**Consultation Response from Ryan Kinder KC,  
 Highways Development Management**

**2023/92490 Former Dowker Works, Dowker Street, Milnsbridge, Huddersfield, HD3 4JX**

**Erection of 35 dwellings with associated access and landscaping (within a Conservation Area)**

**Date Responded: 28/11/2024**

'Highway Areas Plan'

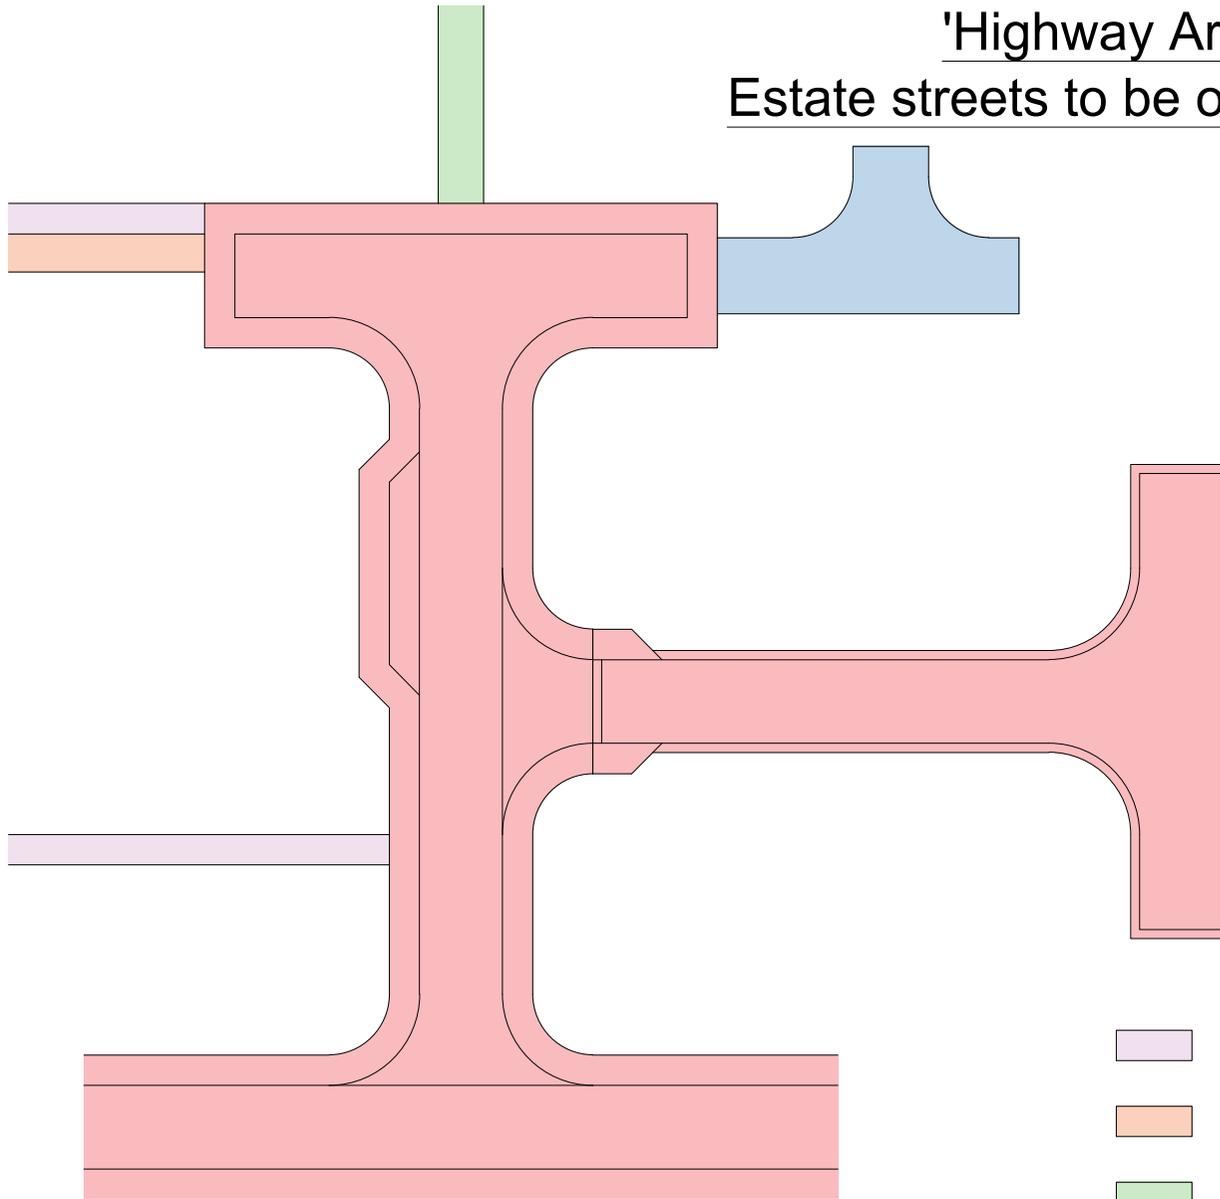
The access road shall be built to adoptable standards, as set out in the Kirklees Highway Design Guide SPD and Highways Guidance Note – Section 38 Agreements for Highway Adoptions March 2019 (version 1) and associated documents. A plan detailing the extends of the internal layout to be adopted has been submitted and considered acceptable.
